# CITY OF ALBUQUERQUE

December 29, 2016

**Re: APS Family School East Side**  
**3303 Monroe Street NE**  
**Traffic Circulation Layout**  
Engineer's Stamp 12-12-16 (G17-D019A)

Based upon the information provided in your submittal received 12-12-16, the above referenced plan cannot be approved for Building Permit until the following comments are addressed:

A1 TRAFFIC CIRCULATION LAYOUT
SCALE: 1" = 20'-0"

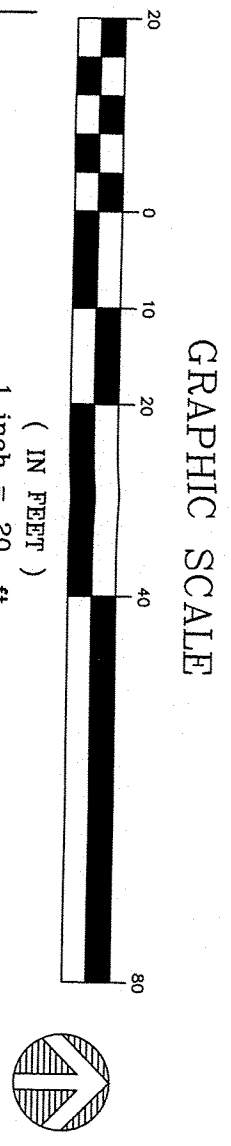
1. Please review and revise plan to provide all information listed on the attached Traffic Circulation Layout checklist.
2. List the number of parking spaces required by the zoning code as well as the proposed number of parking spaces including bicycle and motorcycle parking.

3. Clarify the extents of the current phase. Provide a phasing plan.
4. The traffic circulation layout must be stamped, signed, and dated by an engineer or architect licensed in the state of New Mexico.

5. Identify all existing access easements and rights of way width dimensions.
6. Identify the right of way width, medians, curb cuts, and street widths on Monroe St.

7. Please list the width and length for all existing and proposed parking spaces. Some dimensions are not shown.
8. Please dimension the proposed sidewalk widths.

9. Show all drive aisle widths that effect current phasing. Some dimensions are not shown.
10. Label the compact parking spaces by placing the words "**COMPACT**" on the pavement of each space.

11. The handicap accessible spaces must include an access aisle. Van accessible aisles should be 8ft wide; all others should be 5ft wide.
12. The ADA accessible parking sign must have the required language per 66-7-352.4C NMSA 1978 "**Violators Are Subject to a Fine and/or Towing.**" Please call out detail and location of HC signs.

13. The ADA access aisles shall have the words **"NO PARKING"** in capital letters, each of which shall be at least one foot high and at least two inches wide, placed at the rear of the parking space so as to be close to where an adjacent vehicle's rear tire would be placed. (66-1-4.1.B NMSA 1978)

14. The ADA parking space has a clearly visible, blue, International Symbol of Accessibility painted on the pavement at rear of the space (66-1-4.1.E NMSA 1978) or MUTCD recommends a white symbol on a blue background.

15. Show all drive aisle widths and radii. Some dimensions are not shown.
16. List radii for all curves shown; for passenger vehicles, the minimum end island radius for passenger vehicles is 15 ft. Radius for delivery trucks, fire trucks, etc. is 25 ft. or larger.

17. Provide a min 6" or max 8" high concrete barrier curb or other acceptable barrier between landscaping and parking areas and/or drive aisles. Please call out detail and location of barrier curb.

18. Per the zoning code, a 6 ft. wide ADA accessible pedestrian pathway is required from the public sidewalk to the building entrances. Please clearly show this pathway and provide details.

19. Please specify the City Standard Drawing Number when applicable.
20. Please include a copy of your shared access agreement with the adjacent property owner.
